Urban Design Response			Officer:	Stephen Kilmartin
Description:	Phase 2 Lawsonsteads Whalley			 Ribble Valley Borough Council www.ribblevalley.gov.uk
Application Ref:	2018/0914	Case Officer:	S.K	
Response Ref:	2018/0914/UD/01	Issue Date:	09/11/18

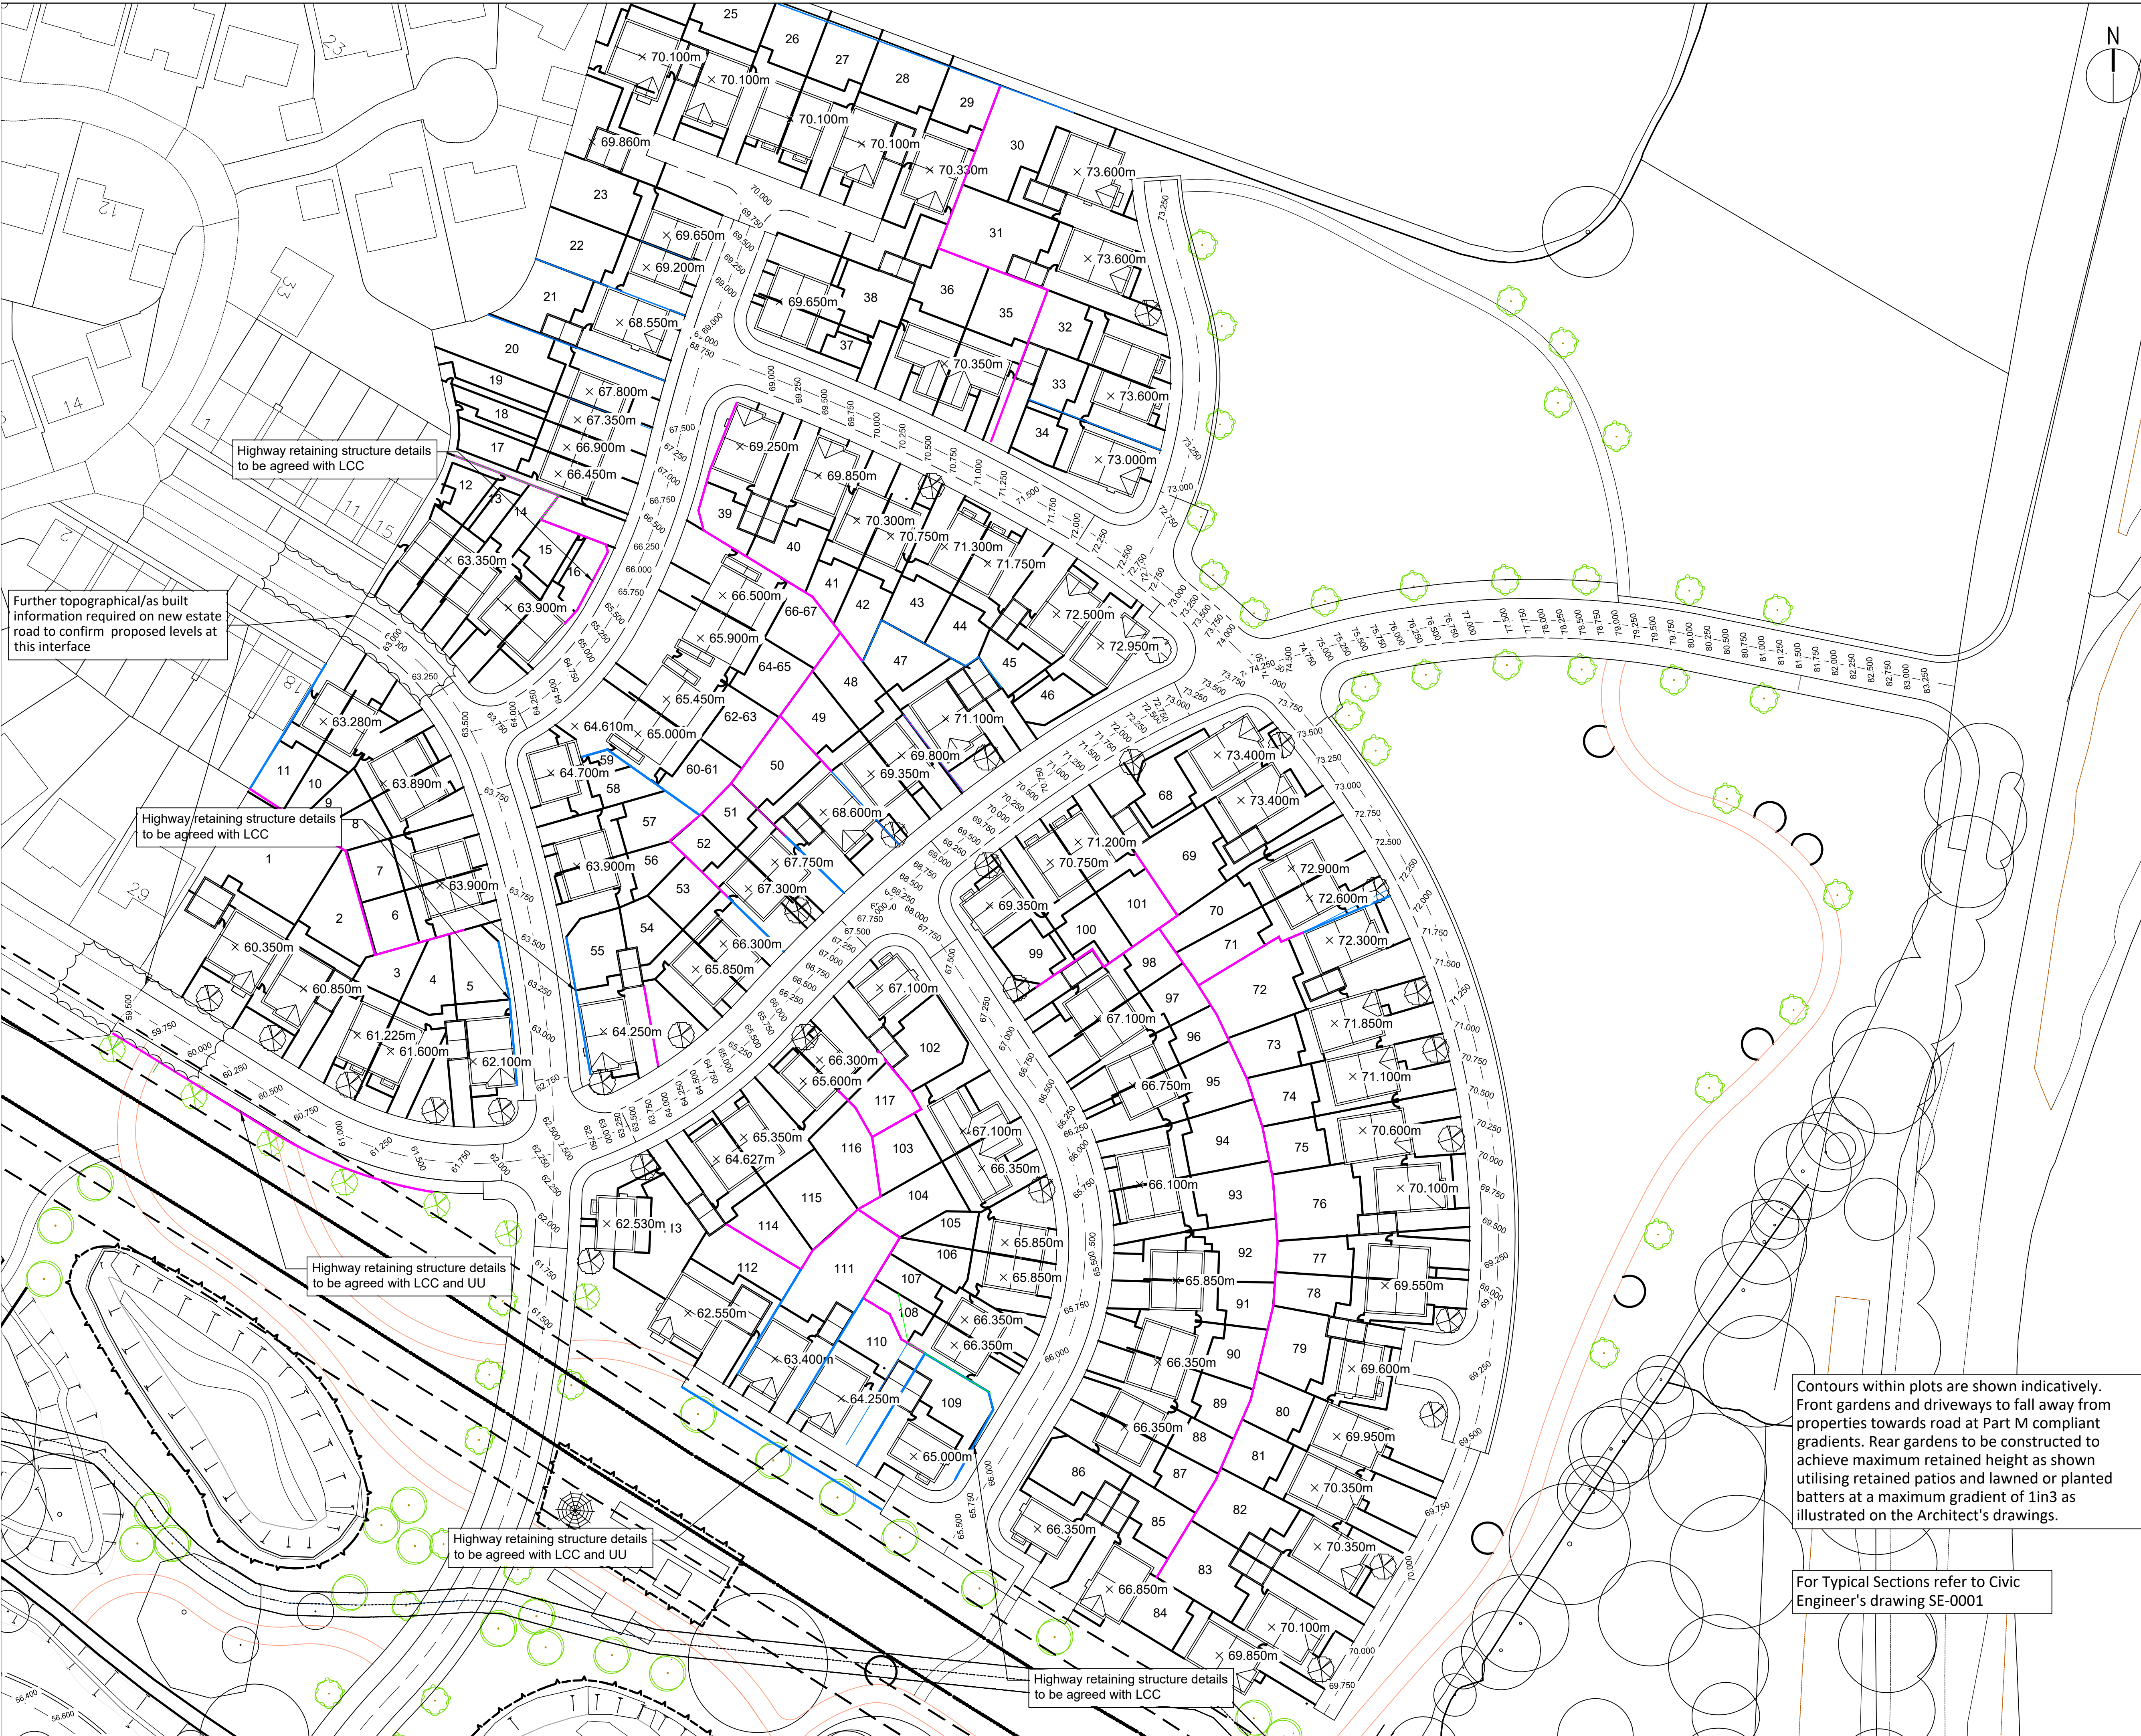
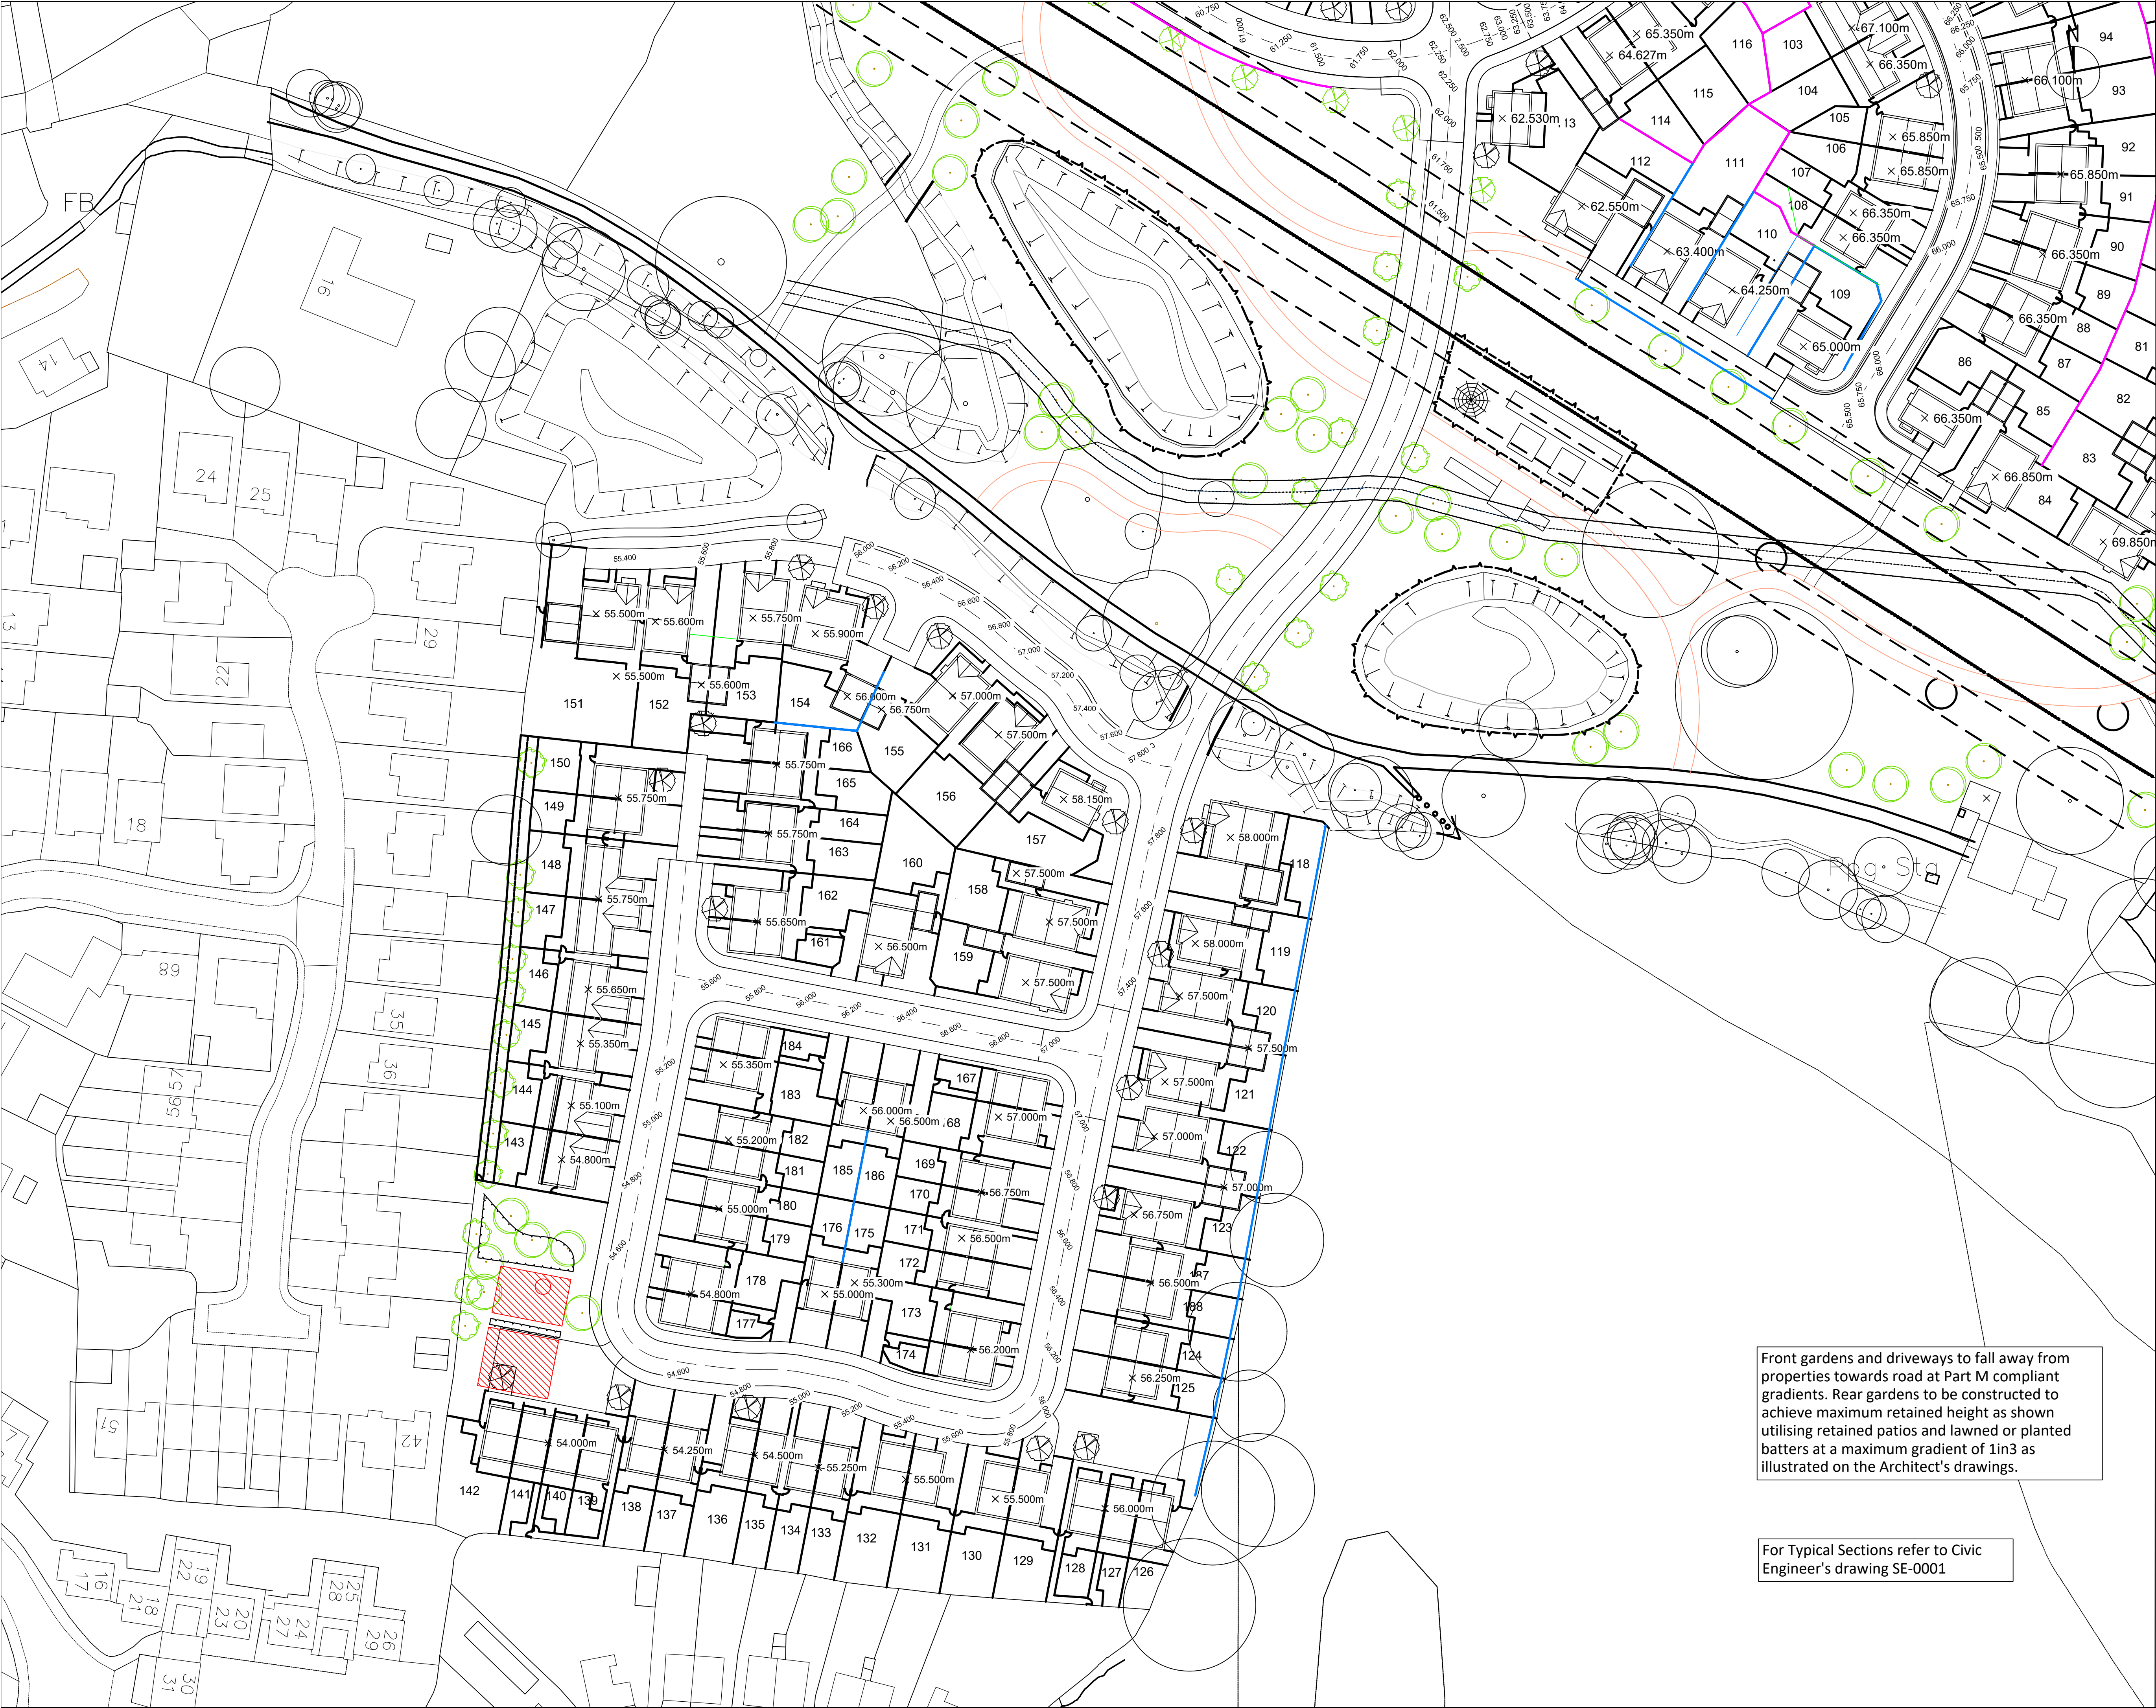
- 4.3** Existing and proposed land levels will be required to be provided as part of the current application, this will allow for an accurate assessment as to how the development will assimilate into the landscape and also how the development will respond to existing built-form. Where the proposal directly interfaces with existing dwellings, particularly the southern development parcel, I would request that existing and proposed sections through the site be provided including details of the height, scale and location of proposed housing in relation to adjacent existing development/built form. You will note that I consider such matters integral to the determination of the application and do not consider such matters should be secured through the imposition of condition.

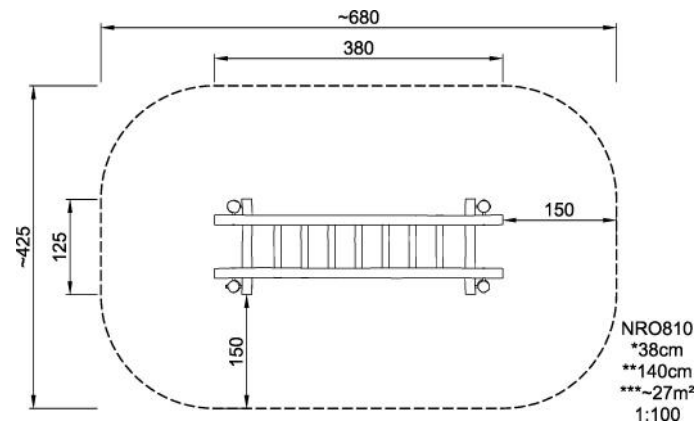
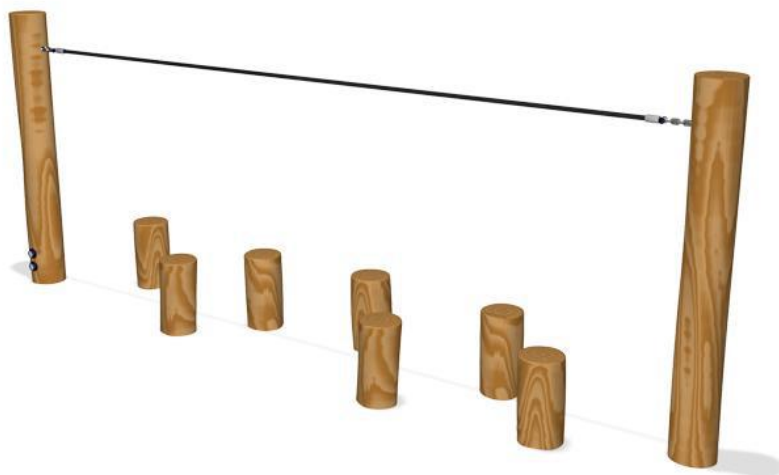
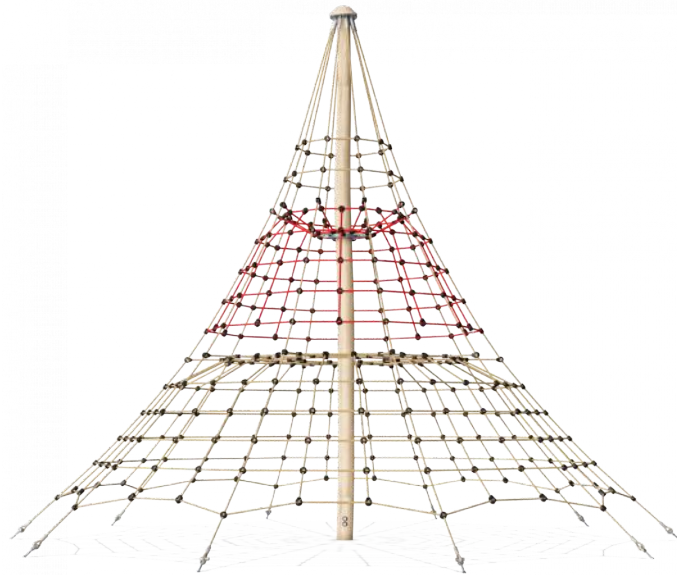
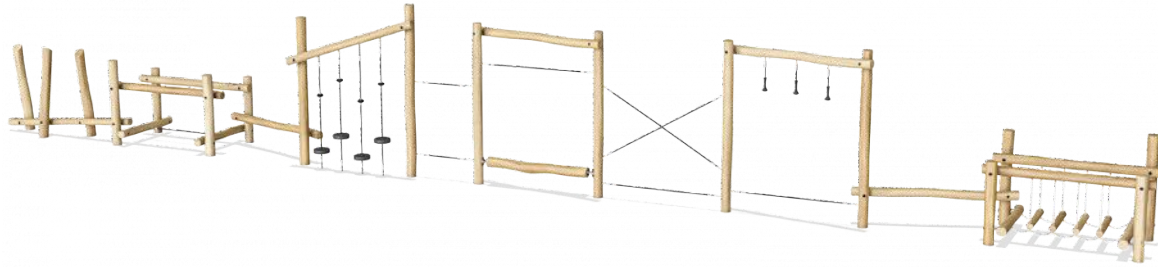
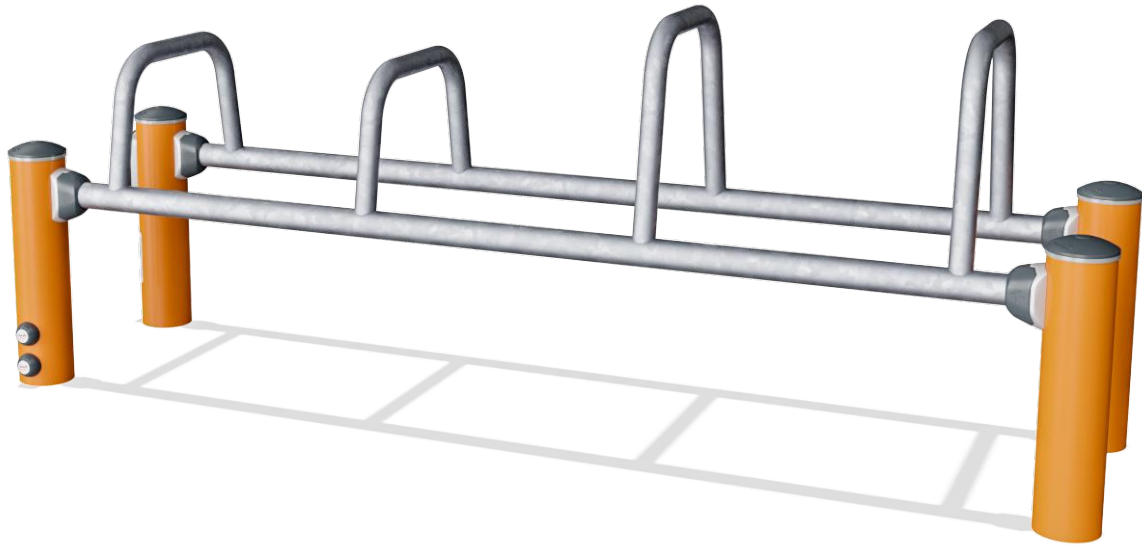
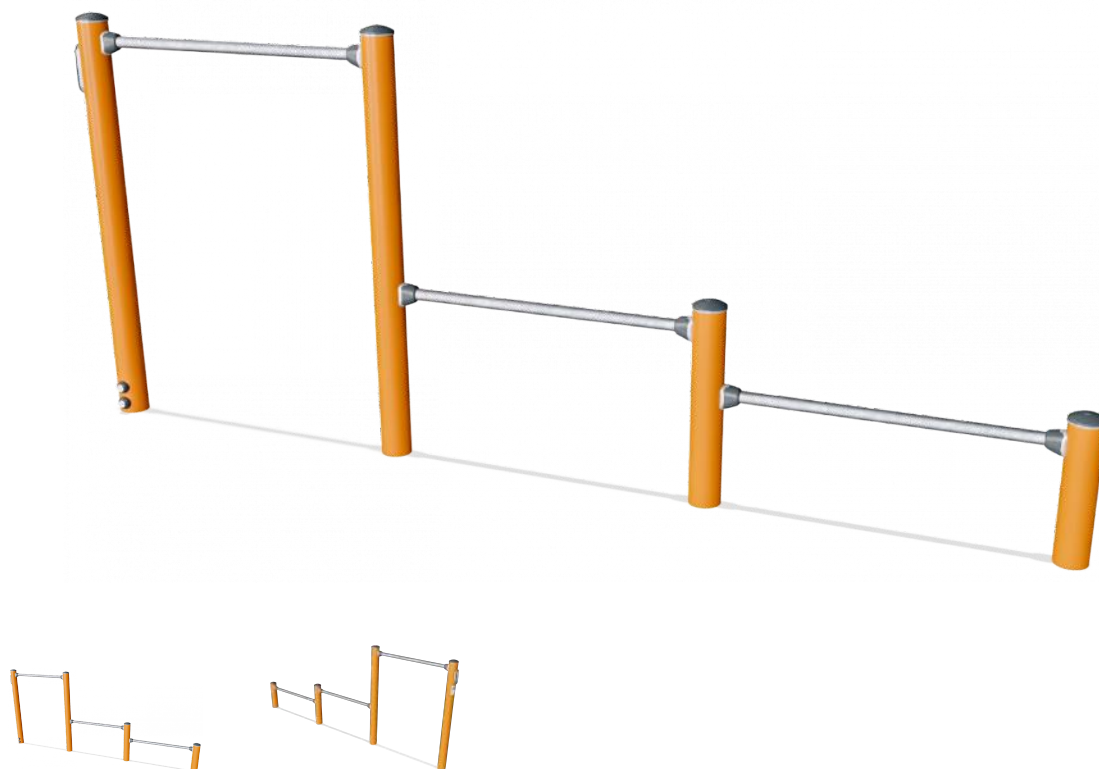
5.5 No details of the proposed trim-trail equipment have been provided at this stage despite requesting this to be submitted as part of the application. For the purposes of public consultation I consider such details should form part of the submission.

PLAN - SINGLE GARAGE  
APPLICABLE TO HOUSE TYPE A, B, C AND D  
SEE SITE LAYOUT DRAWINGS FOR LOCATION

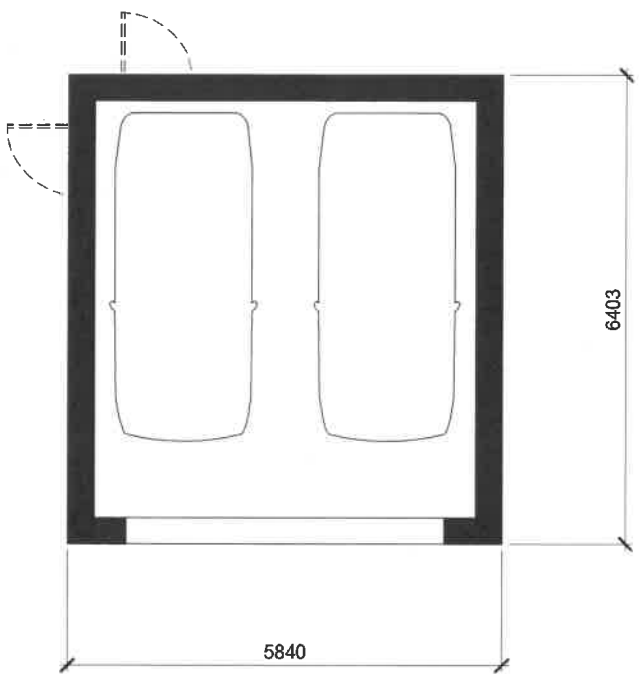
3.1 Integral and detached single garages must have a minimum internal depth of 6m and width of 3m to be counted towards usable parking provision within the development.
